M/s Kathryn Powell,
Senior Case Manager,
The Planning Inspectorate,
3/20 Eagle Wing,
Temple Quay House,
2, The Square,
Bristol BS2 6PN

25th.October 2012

A556 Knutsford – Bowden Environmental Improvement Scheme.

Cuttings and embankments

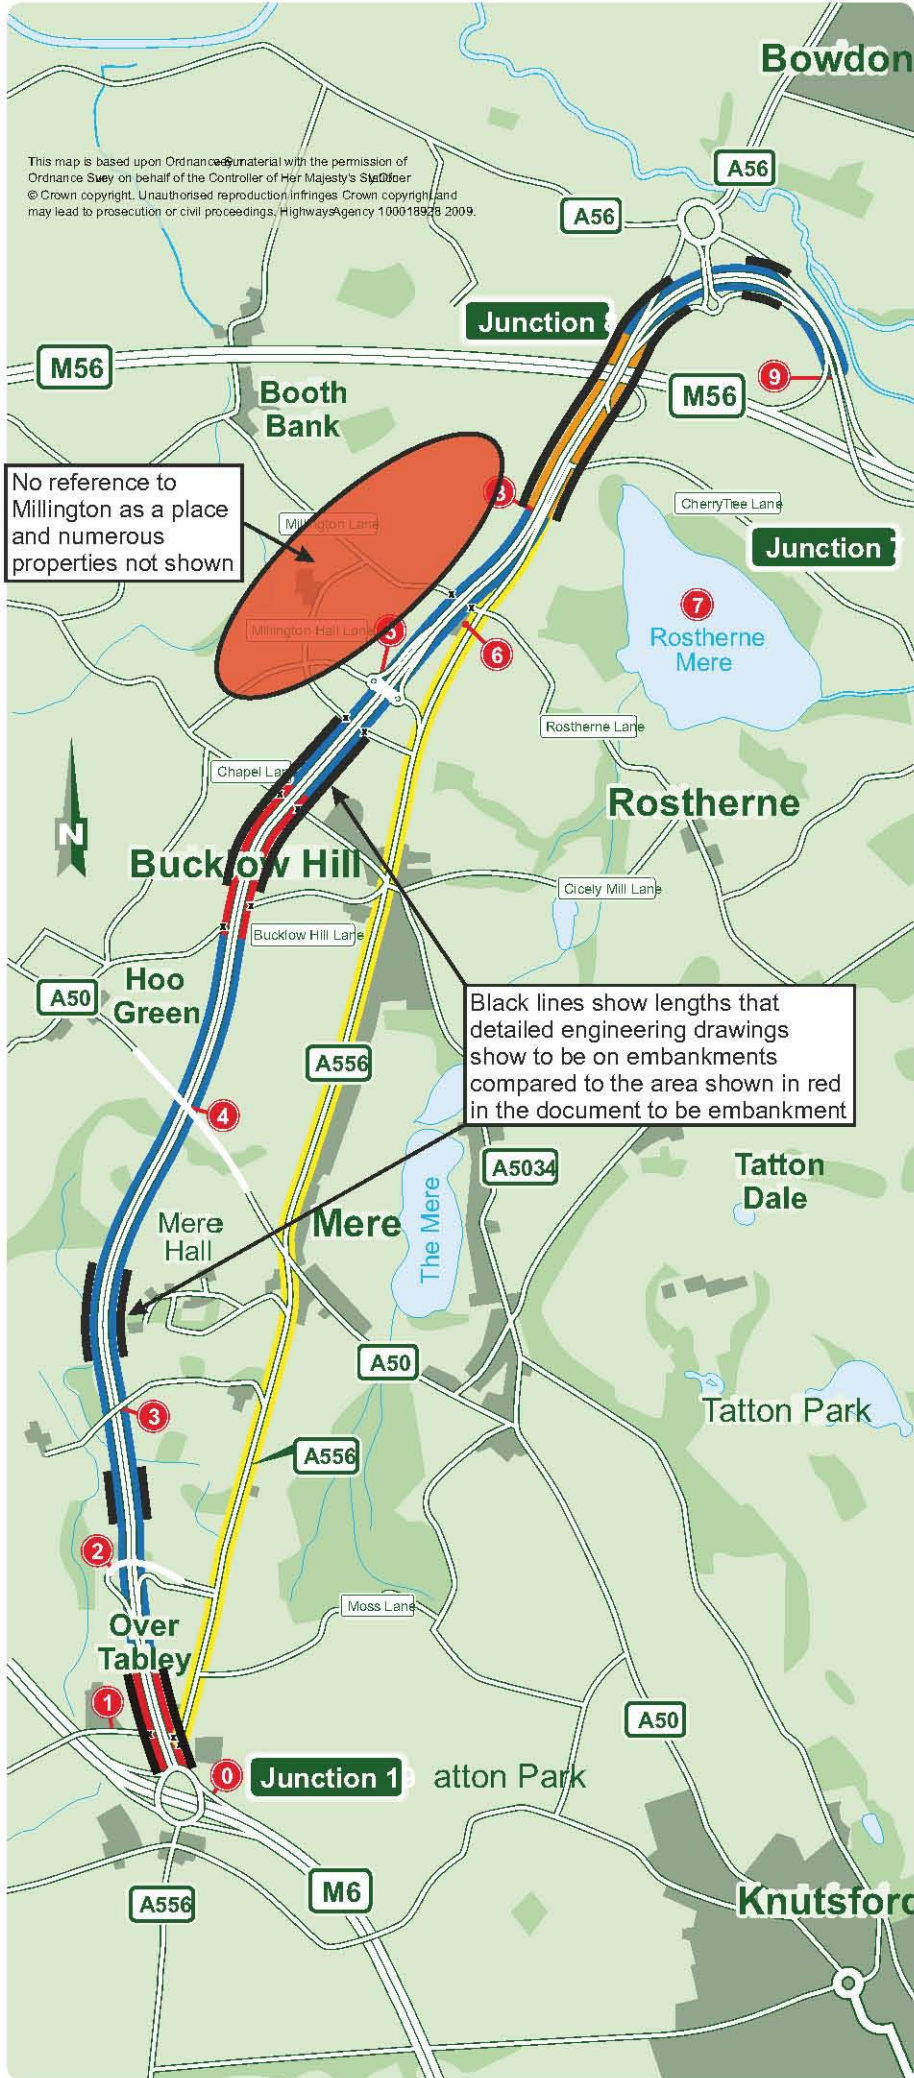
The Summary Document (SD) is, at best, extremely misleading in several respects; diagrams illustrate all properties to the east of the road but do not acknowledge any of the homes to the West; The maps at the Public Exhibition confirm that cuttings to be provided along the majority of the route (promised in 2007), which appear in the SD diagrams, will actually **not** be provided after all, despite the HA’s assurances to the public that they intend to “minimise the environmental impacts of the scheme”; Non-locals are being asked to complete a questionnaire based on flawed and misleading information, believing the scheme to have little or no impact since there appears to be little more than empty fields to the West of the road. The public cannot possibly make an informed decision and therefore NID cannot consider the results of the questionnaires.
